A303 Sparkford to Ilchester Dualling Scheme TR010036

9.2 Environmental Statement Table of Errata

Environmental Statement Table of Errata

Version	Date	Status of Version
Rev A	January 2019	Submission for Deadline 2
Rev B	May 2019	Submission for Deadline 6
<u>Rev C</u>	<u>May 2019</u>	<u>Submission for Deadline 7</u>

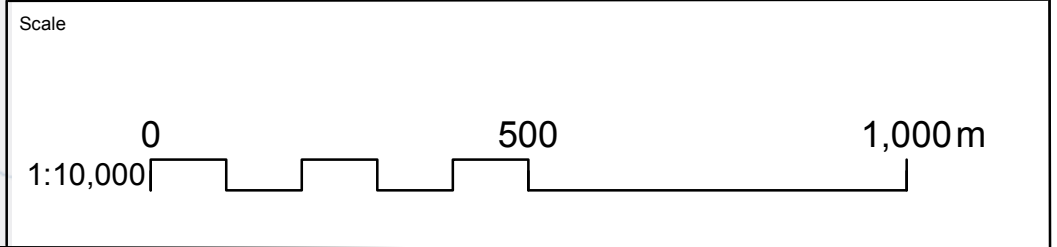
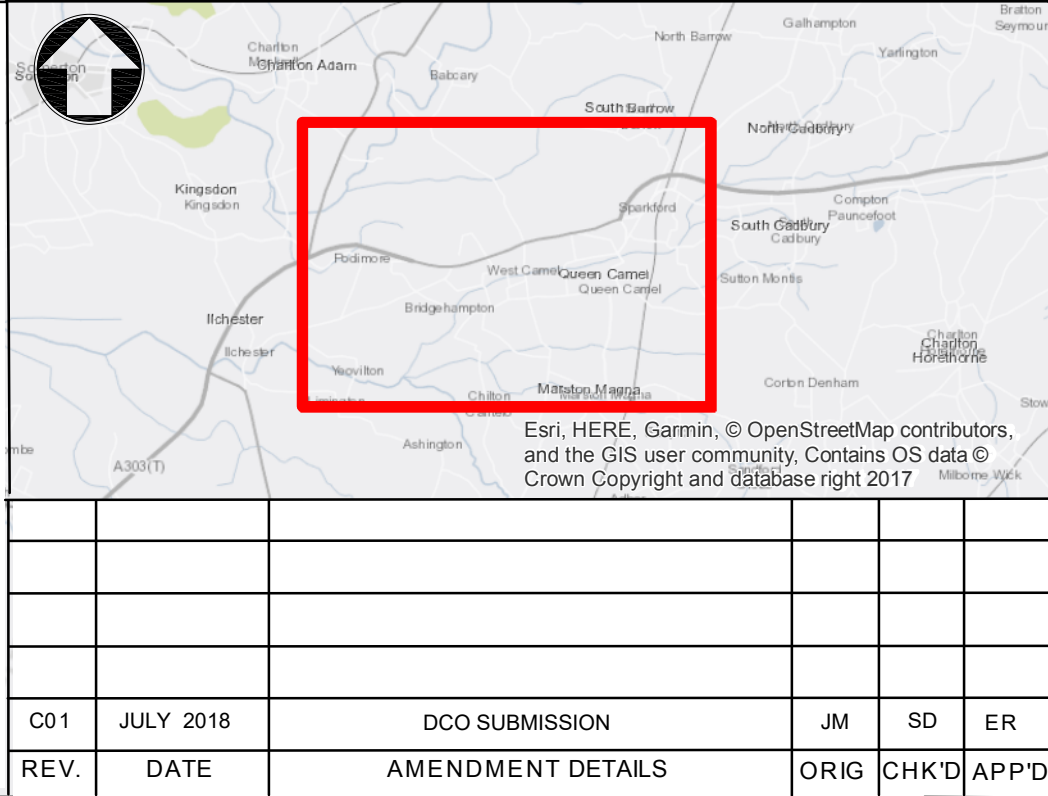
1.4.11	Volume 6.1 Environmental Statement Chapter 11 Noise and Vibration (APP-044)	22 - 23	The operational study area depicted in Figure 11.1 in Chapter 11 of the ES (APP-048) is inconsistent with the operational study area described in Chapter 11 section 11.6. Can this be rectified please?	Amended in response to ExA question 1.4.11. Referred to the wrong appendix figures in paragraphs 11.6.1 and 11.6.2.	Paragraphs 11.6.1 and 11.6.2 of Environmental Statement Chapter 11 Noise and Vibration (APP-048) are amended to: <i>"The assessment area for temporary noise and vibration impacts during construction is 300 metres from construction activity (seen in Figure</i>

ExA- Question- no-Referenc e	Document number	Page no	ExA Written Question	Reason for amendment to the Environmental Statement	Amendment to the Environmental Statement
					<p><i>11.42 Construction Noise Study Area, Volume 6.2) due to the nature of the noise sources, the typical distances from source to receptor, and professional experience for the likely area of potential adverse effects from similar highways construction assessments."</i></p> <p><i>"HD213/11 provides the methodology for assessment of road projects within the UK. The methodology, which has been applied for the purposes of this assessment, requires that the study area is identified as an area within 1 kilometre of the physical works associated with the scheme. Within this study area, road traffic noise calculations are performed at any sensitive receptor within 600 metres of a road where there is a possibility of a change of 1dB LA10,18hr upon scheme opening, or 3dB LA10,18hr in the long term. The operational noise calculation area is shown in Figure 11.21 Operational Noise Study Area, Volume 6.2."</i></p>
